**WELWYN HATFIELD BOROUGH COUNCIL  
EXECUTIVE DIRECTOR - PLANNING, PUBLIC PROTECTION AND GOVERNANCE**

**DELEGATED APPLICATION**

**Application No:** 6/2018/1715/EM  
**Location:** 171 Parkway Welwyn Garden City AL8 6JA  
**Proposal:** Erection of single storey rear extension  
**Officer:** Ms Louise Sahlke

Contract	PROPOSED EXTENSION		PROPOSED ELEVATIONS		Scale	Date	Drawn	Checked
	171 PARKWAY				1:100	06.2018		
	WELWYN GDN CITY, HERTS, AL8 6JA		Title		Drawing Number		Revision	
					MP-05			A

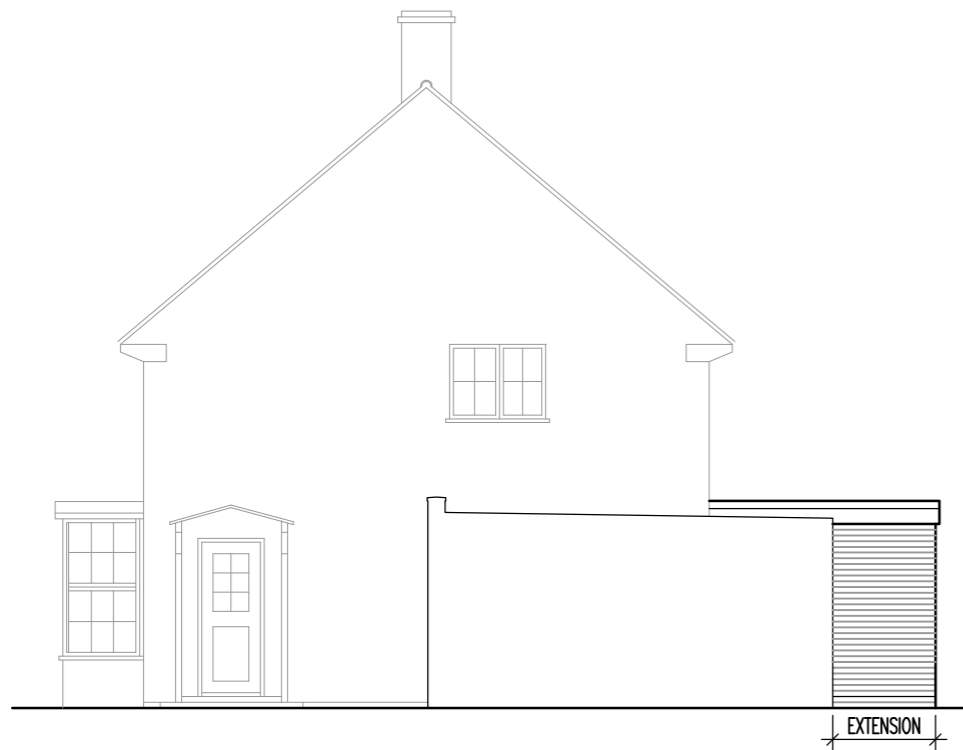
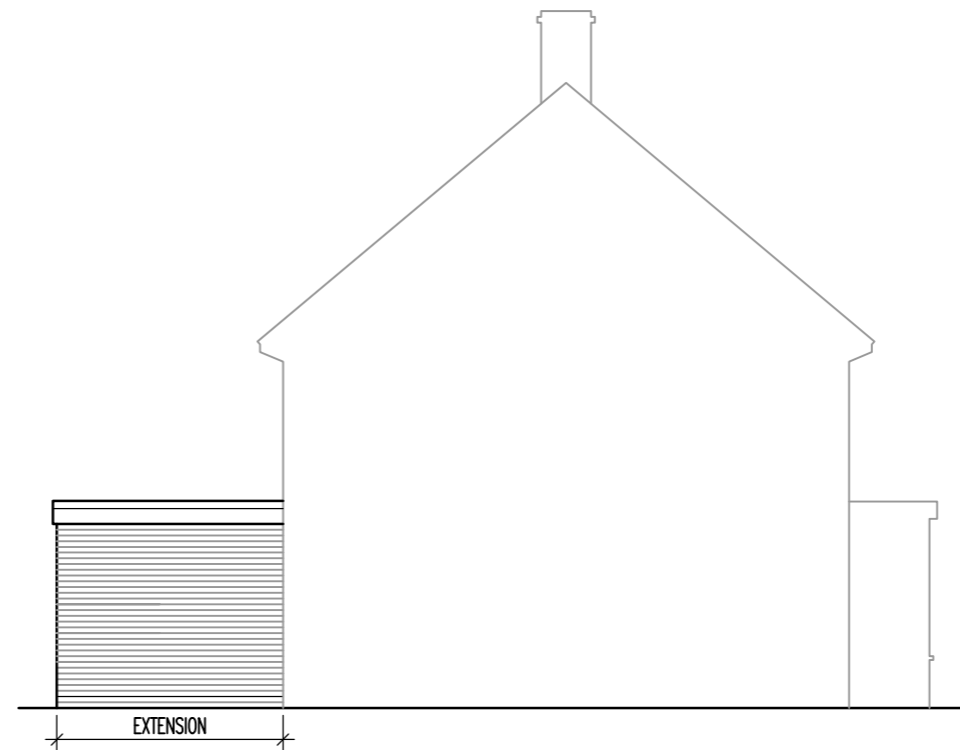
<b>Considerations</b>			
<b>Design (form, size, scale, siting) and Character (impact upon amenities and values of Garden City)</b>	<p>Within the Garden City, single storey rear extensions are characteristically designed with flat roofs in order to maintain a consistent design and appearance, remaining adequately subordinate in scale to the property. The proposed extension would feature a flat roof design which would be of an acceptable height, which would not harm the character and appearance of the host dwelling or streetscene. The overall height and depth of the single storey rear extension is acceptable. The single storey rear extension is considered proportionate to the size of the original property and is not highly visible from</p>

<p>the streetscene. The proposed doors are considered acceptable. Therefore the proposed rear extension is considered acceptable.</p> <p>No details have been provided of the external materials and therefore should estate management consent be approved, a relevant condition would be required.</p>
<b>Impact on neighbours</b>	<p>The proposal is not considered to result in a loss of privacy. There are no side windows in the proposed rear extension.</p> <p>Given the scale and location of the proposed development it is considered a reasonable relationship would be maintained with adjoining properties.</p> <p>The insertion of a rear door would not impact on residential amenity.</p> <p>The proposed development is considered to maintain and enhance the amenities and values of the Garden City and is therefore in compliance with the Estate Management Scheme.</p>
<b>Landscaping issues (incl. hardstandings)</b>	None
